**DELEGATED DECISION TO DETERMINE APPLICATIONS FOR
NON-MATERIAL AMENDMENTS**

Reference No: **2024/NM/93259/W**

Site Address: **8, Tor View, Brockholes, Holmfirth, HD9 7BQ**

Description: **Non material amendment to reduce the scale of previous permission 2023/93404 (demolition of existing garage and workshop and erection of single and part two storey side extension) to a single storey development removing roof lights and reducing the height of the extension and footprint of the extension.**

Client: Mr & Mrs Hide	
Project: 8 Tor View Brockholes HD9 7BQ	
Drawing: Proposed Layouts	
Date: Nov 2023	Scale: 1:100 @ A3
Drawing No: 2327/112	Rev: A

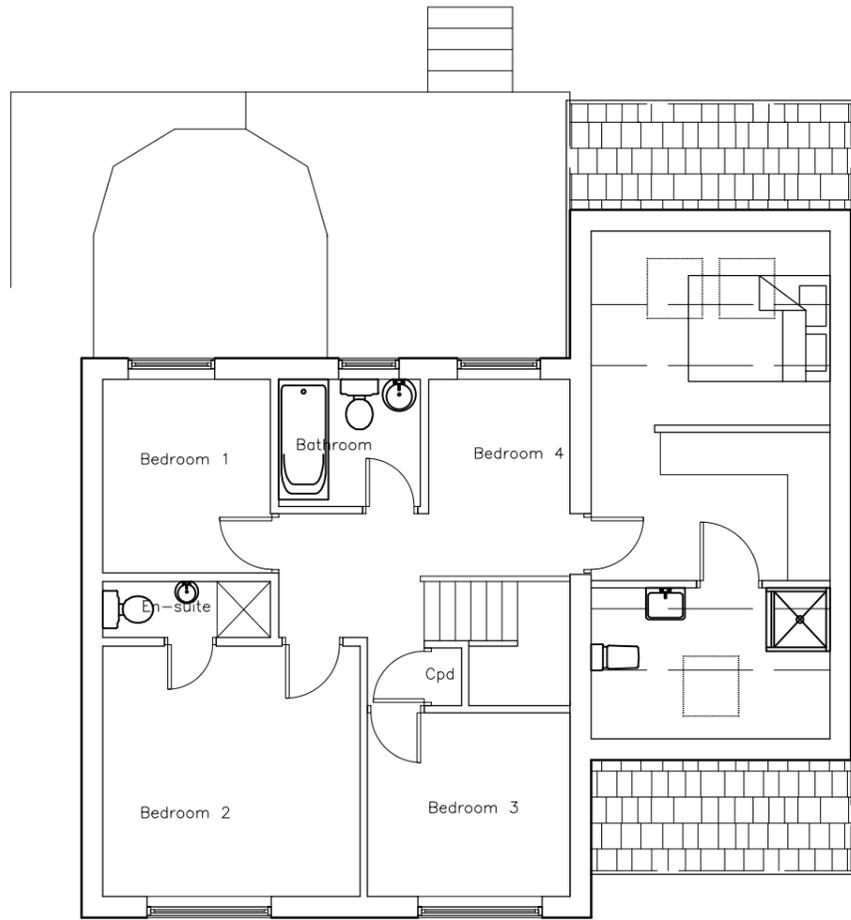
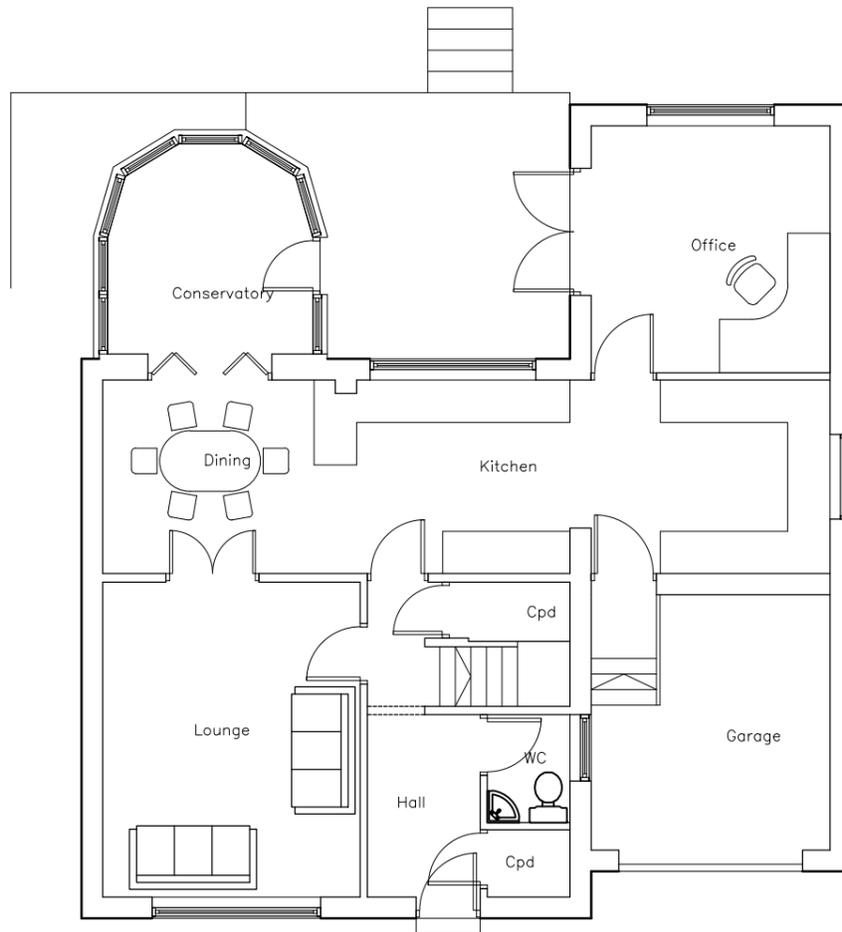
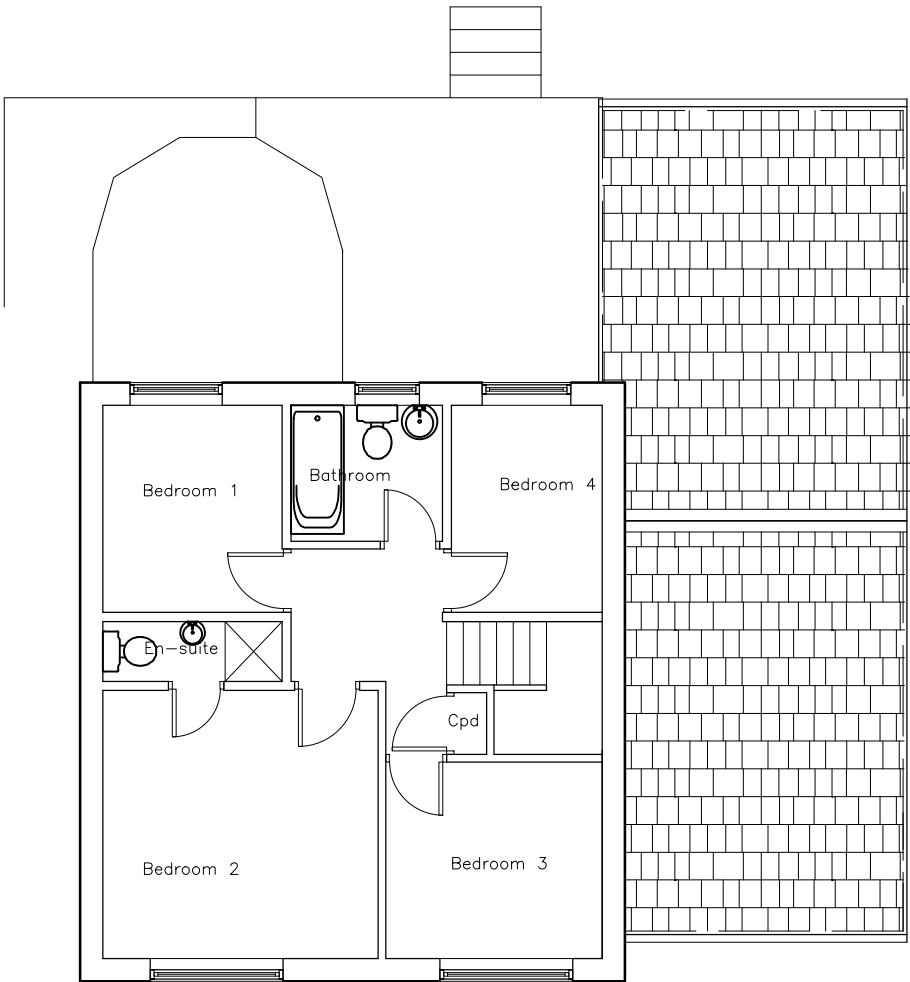
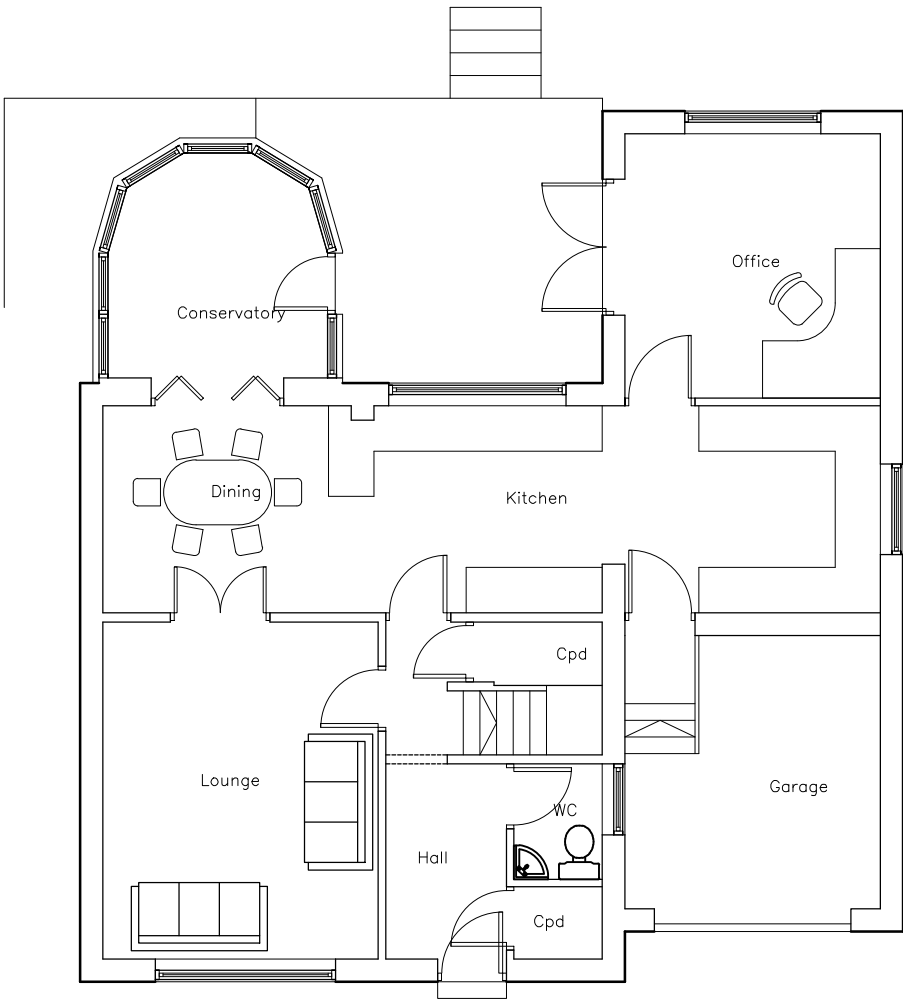
The amendments shown on drawing No's. 111_A, 110_A, and 112_A are considered appropriate to be regarded as a non-material amendment to the previous planning approval 2023/93404.
